PLANNING COMMENTS & APPLICANT RESPONSES

AGENDA ITEM: DFT Project Number: PR-2023-008423

Application Number: SI-2023-00606 Project Name: 4821 Pan American West – Lexus

Request: Major Site Plan Amendment

**C00.1**

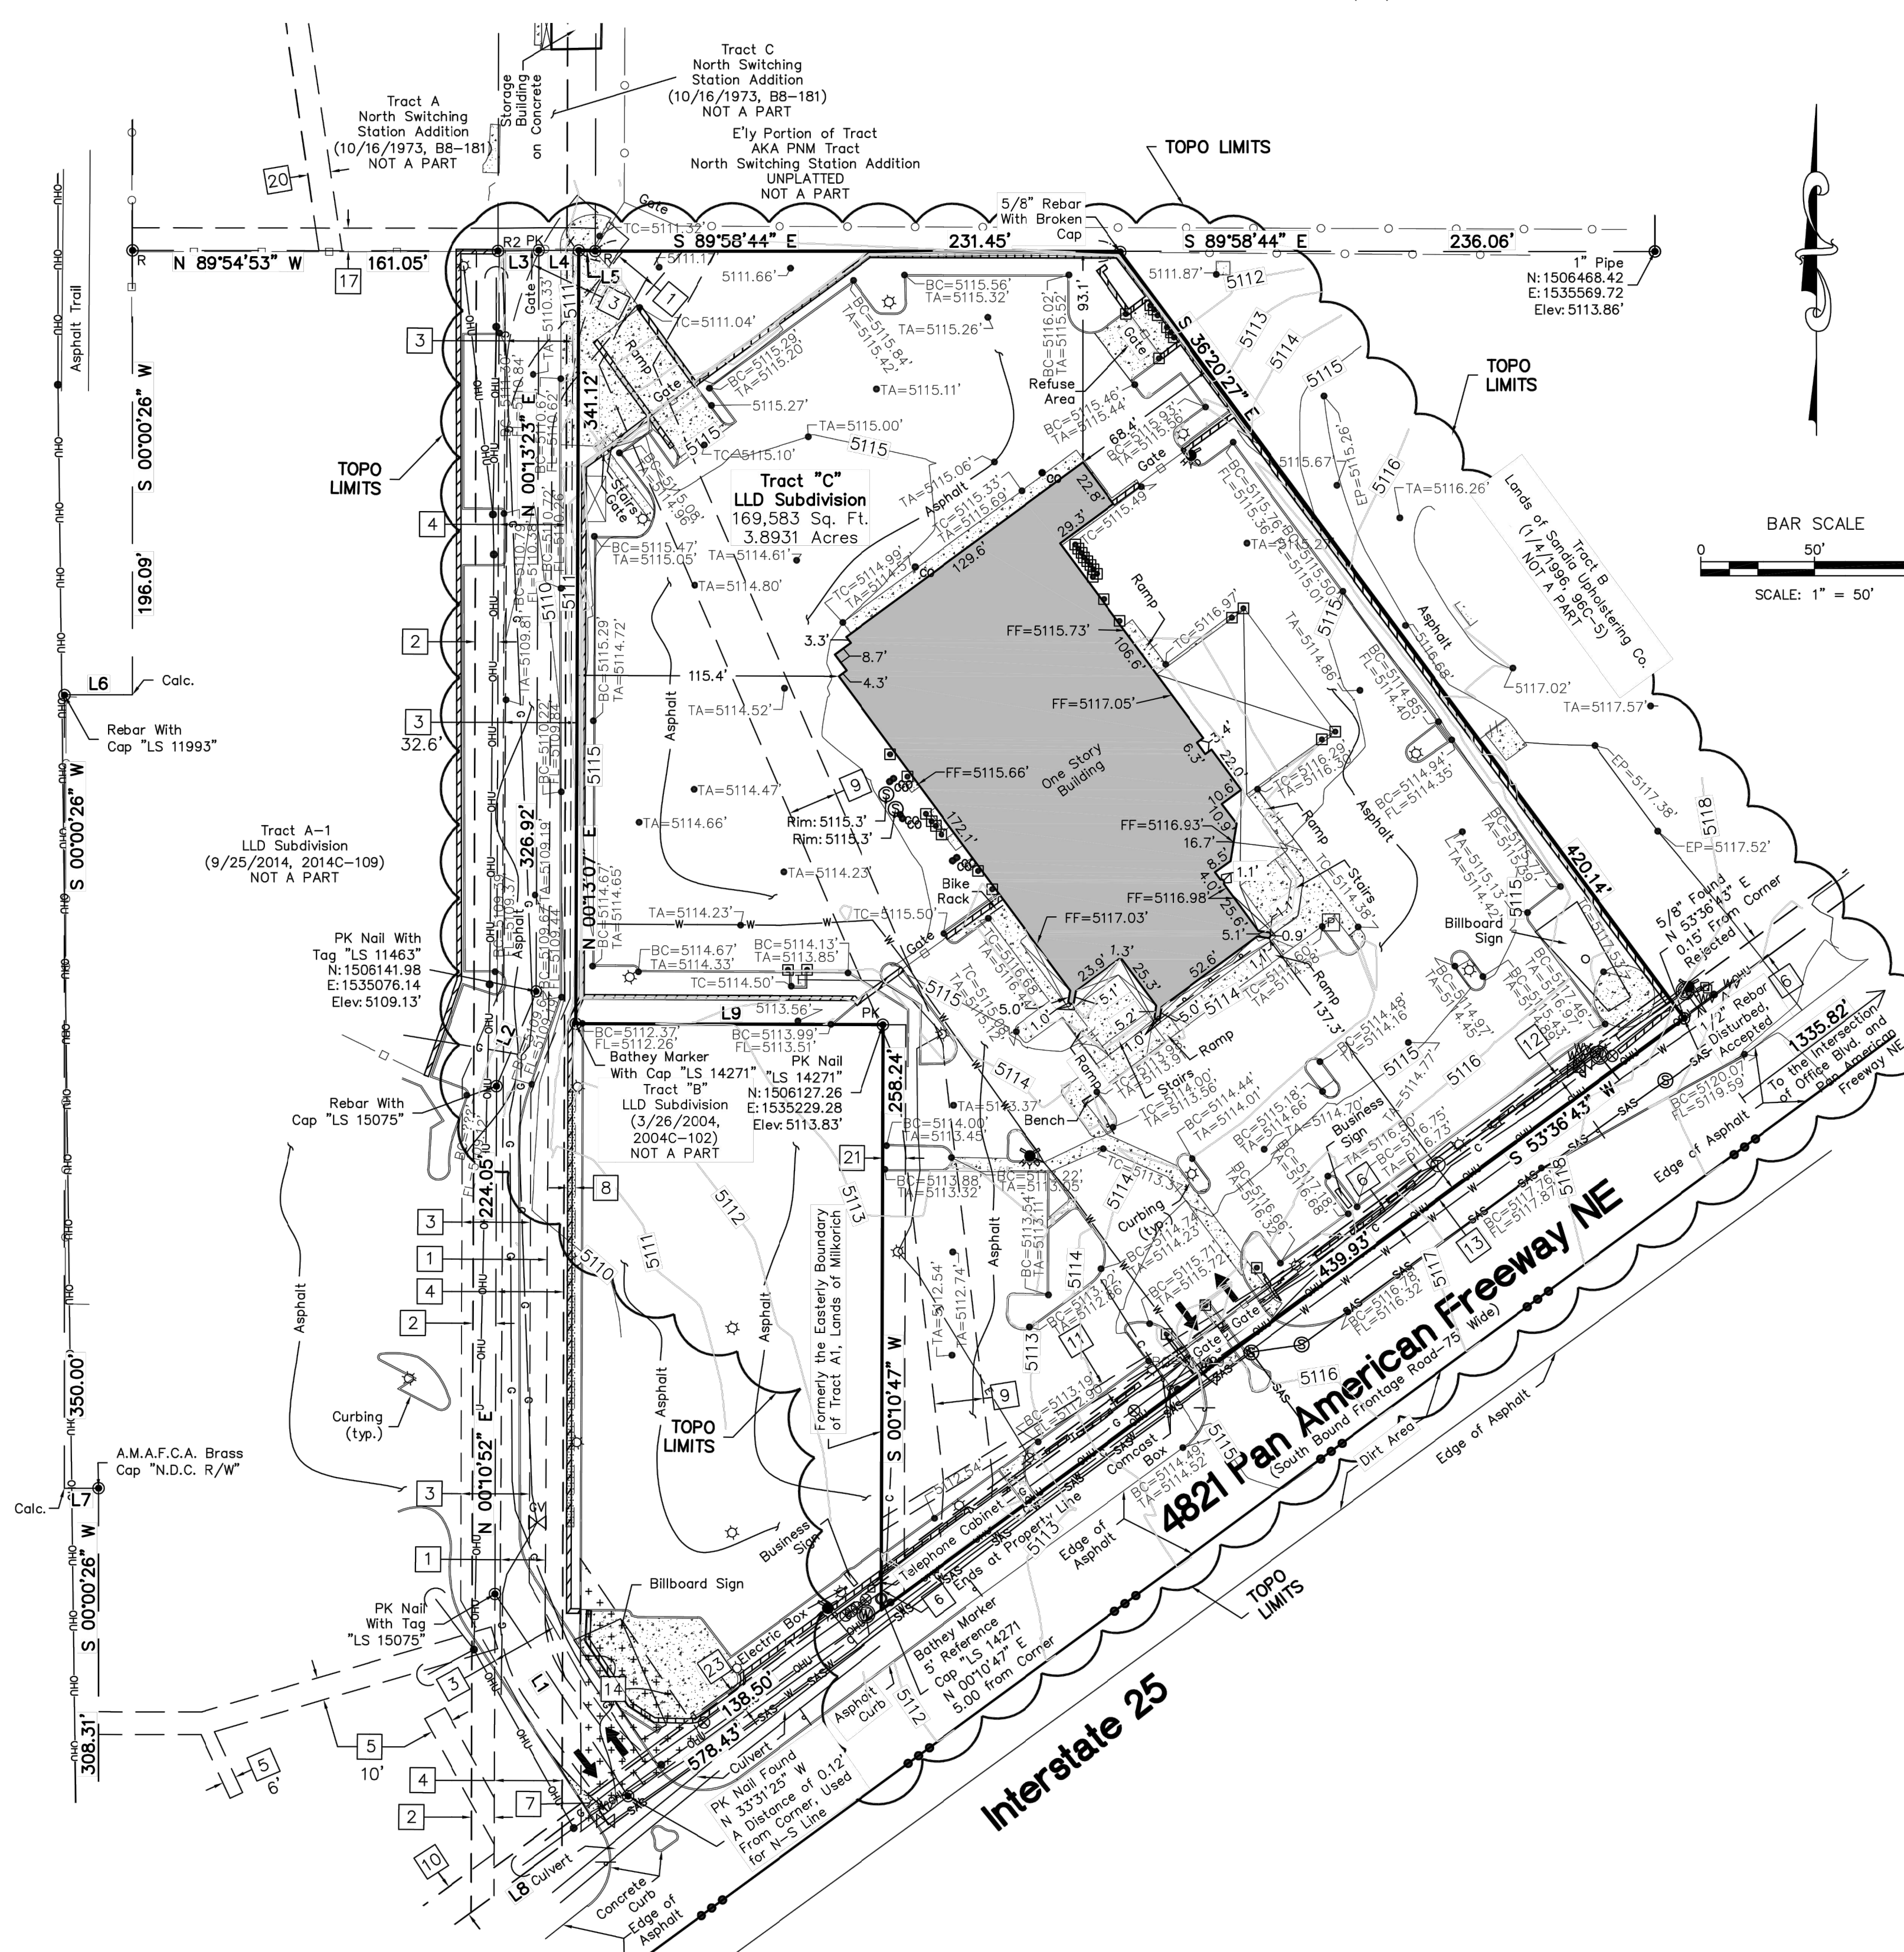
13. *Clarify existing easements noted in orange for AGIS map.

RESPONSE: The referenced easement was labeled on the existing conditions plan (survey) as a PNM Easement. We've added an additional label on the site plan to make it easier for staff to identify. This easement is not impacted by our proposed development.

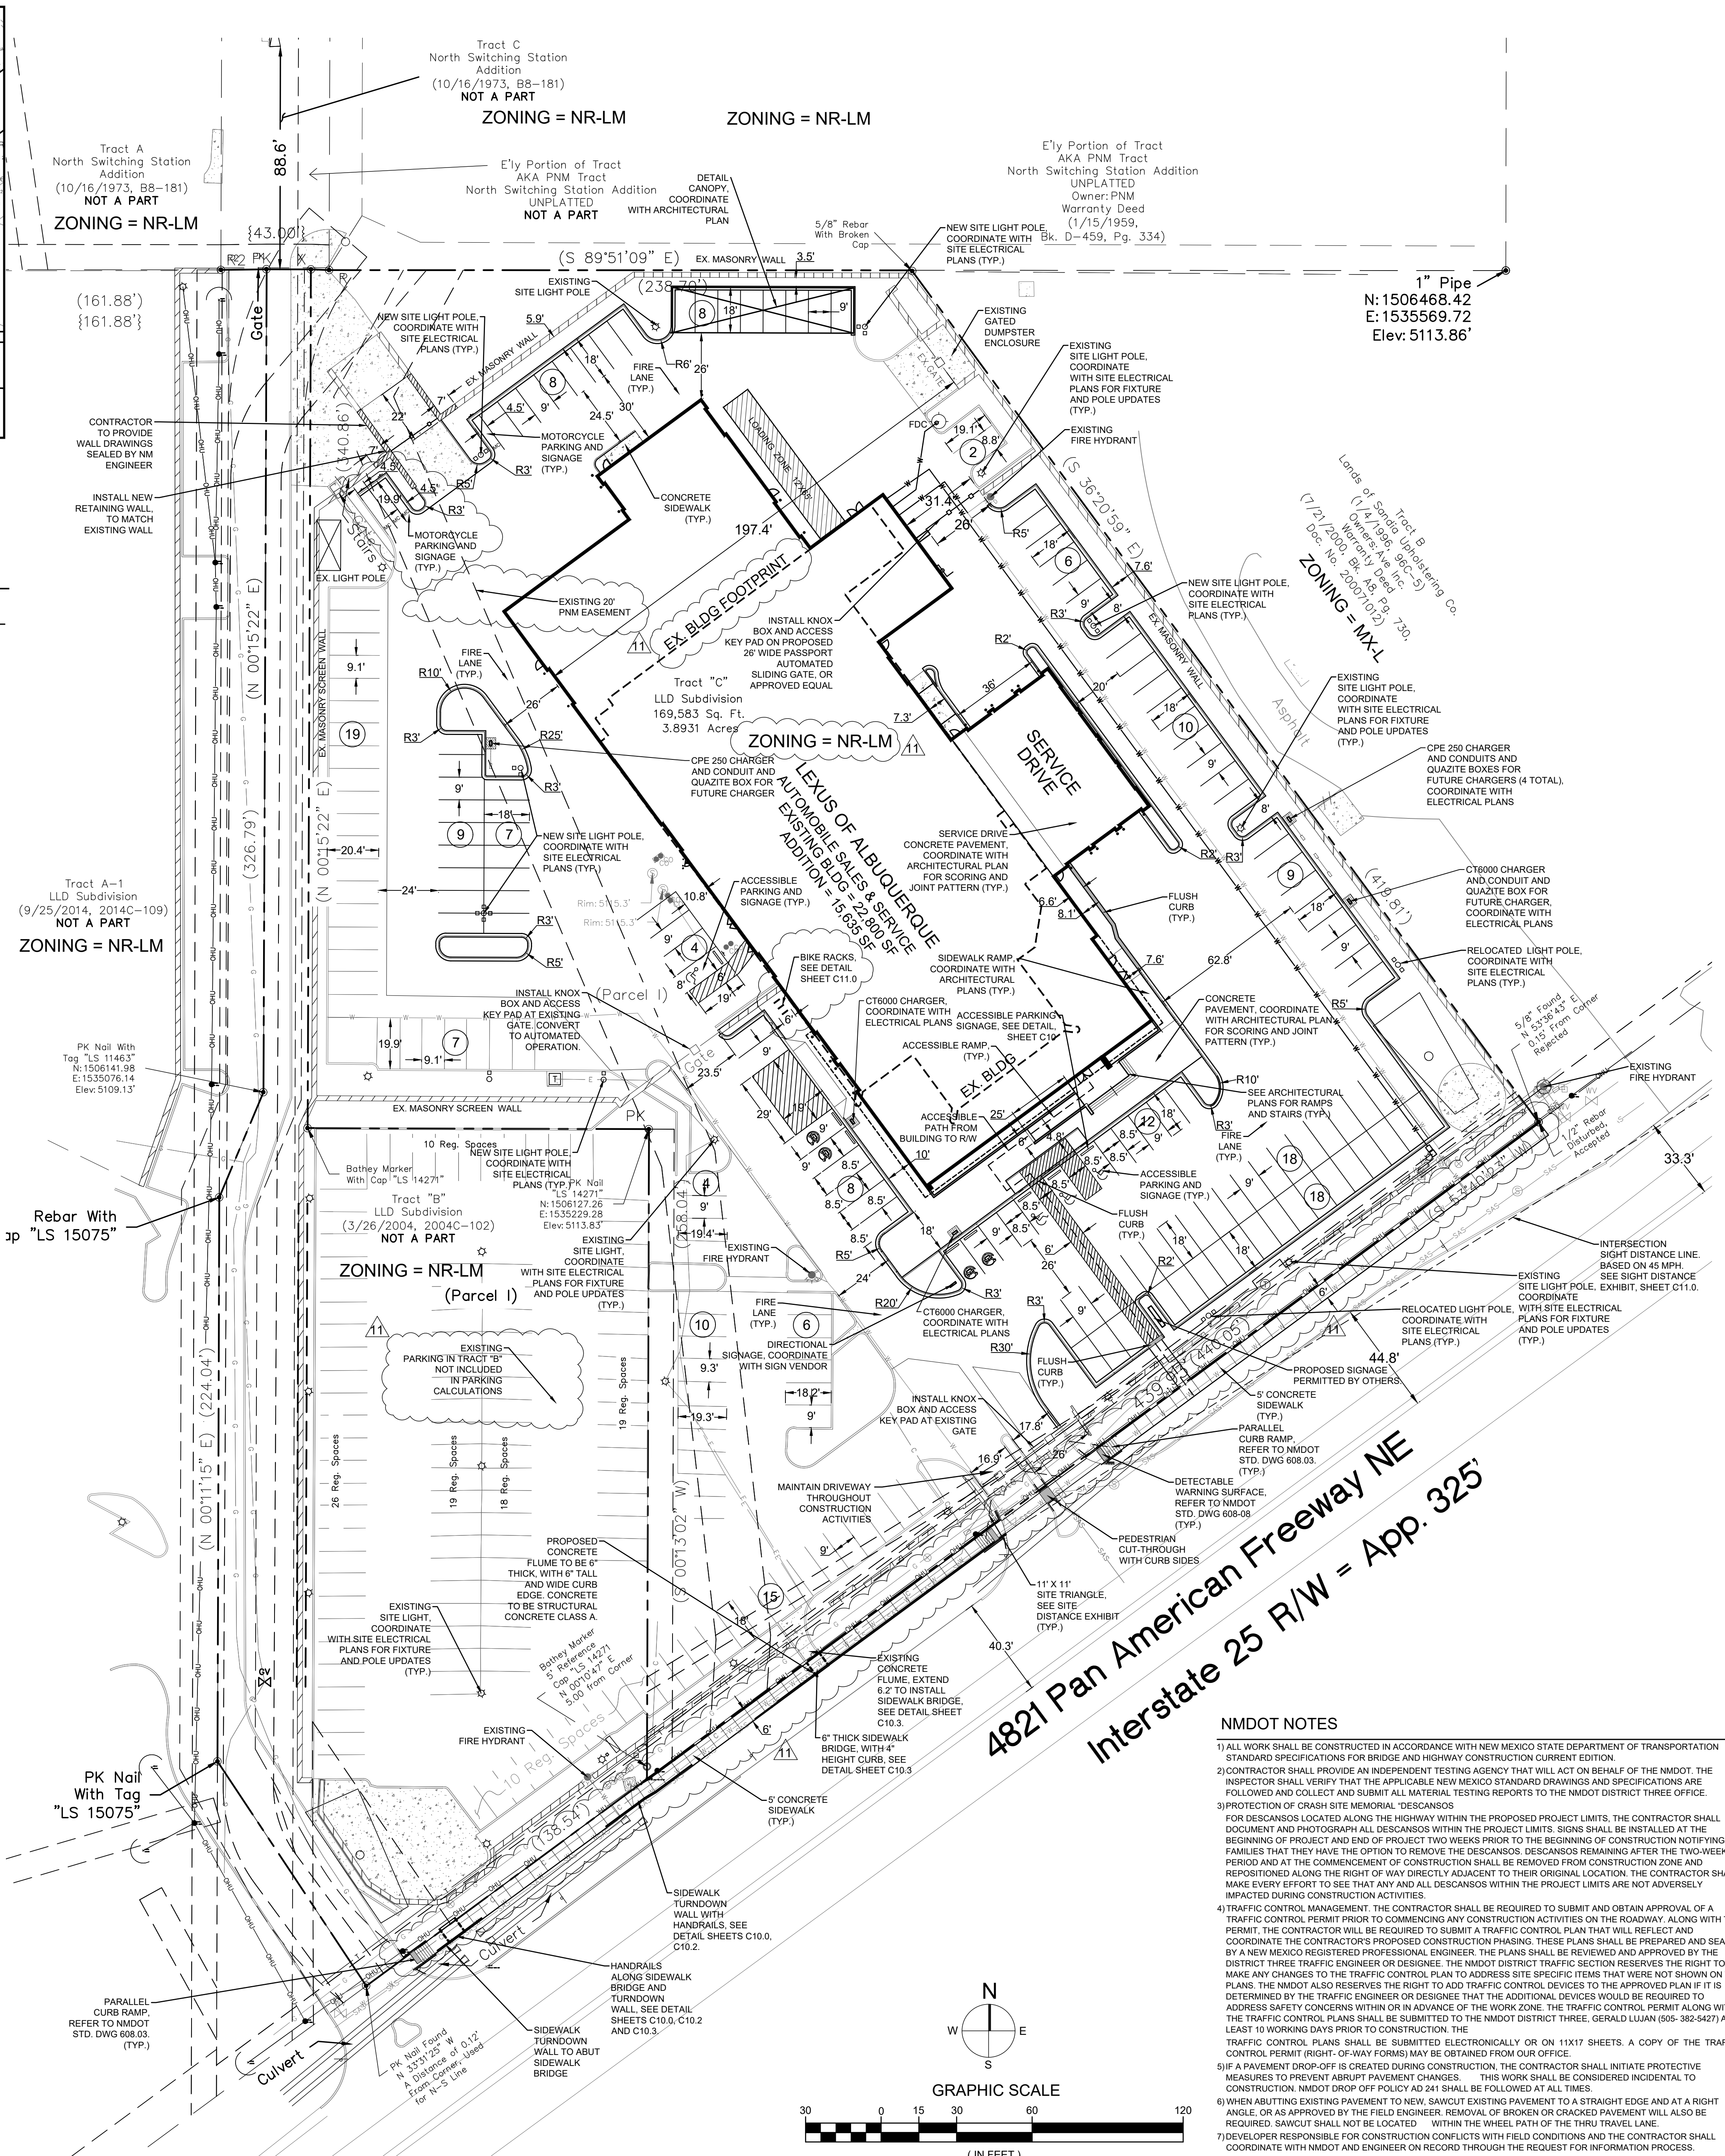
6. Sheet C02.0 should note NR-LM zoning on the subject site.

Note #3 in Site Design Data table on the Site Plan submitted indicates NR-LM zoning for the site. As requested by staff during our zoom meeting, we have added a redundant zoning label within the site boundary.

5. On the Site Plan sheets and elevations, clearly note areas of building additions and new landscaping with clarity about existing conditions.

RESPONSE: We have added a line on the site plan indicating the extent of the existing building such that staff can tell what constitutes the new addition. The landscape plan submitted clearly indicates existing vs. proposed plantings.
